From: Laura Gibbons
Sent: 04 February 2019 12:43
To: Planning.Responses
Cc: Amber Willard
Subject: RE: Planning Consultation on BN/1/19/DOC

Engineers Comments Regarding Conditions 3 and 4

APPLICATION **BN/1/19/DOC**

Description of Works: Approval of details reserved by condition imposed under
BN/53/18/HH relating to conditions 3-surface water drainage &
4-discharge of any flows to watercourses.

Project:	37 Hill Lane, Barnham	Date:	Jan 2019	Made by:	KS	Sheet No.	1
CALCULATION SHEET		Job No.	1870	Chkd:	-	Rev.	0

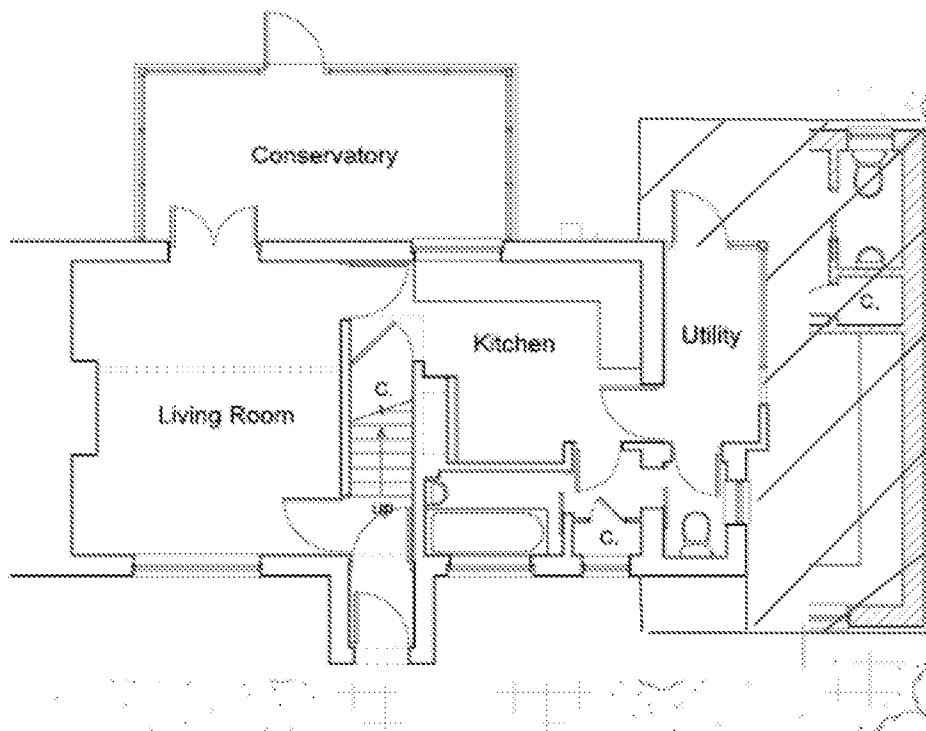
1. A 40% allowance for climate change must be applied to design
2. Worst case infiltration rates must be used in design.
3. An infiltration rate of $\times 10^{-7}$ is not appropriate for the use of infiltration.
4. It is stated that a half drain time of 24 hours cannot be achieved. The applicant must demonstrate that the 1 in 10 year plus 40% climate change event can half drain within 24 hours. If this cannot be achieved attenuated discharge will have to be used.
5. Please supply a location plan showing the location of groundwater monitoring and infiltration testing relative to the proposed drainage scheme.
6. It is stated that the watercourse is on the opposite side of the road, this is incorrect. There is an ordinary watercourse on both sides of the road.
7. Neighbouring proposals were for attenuated discharge to watercourse, this is likely to be required here.
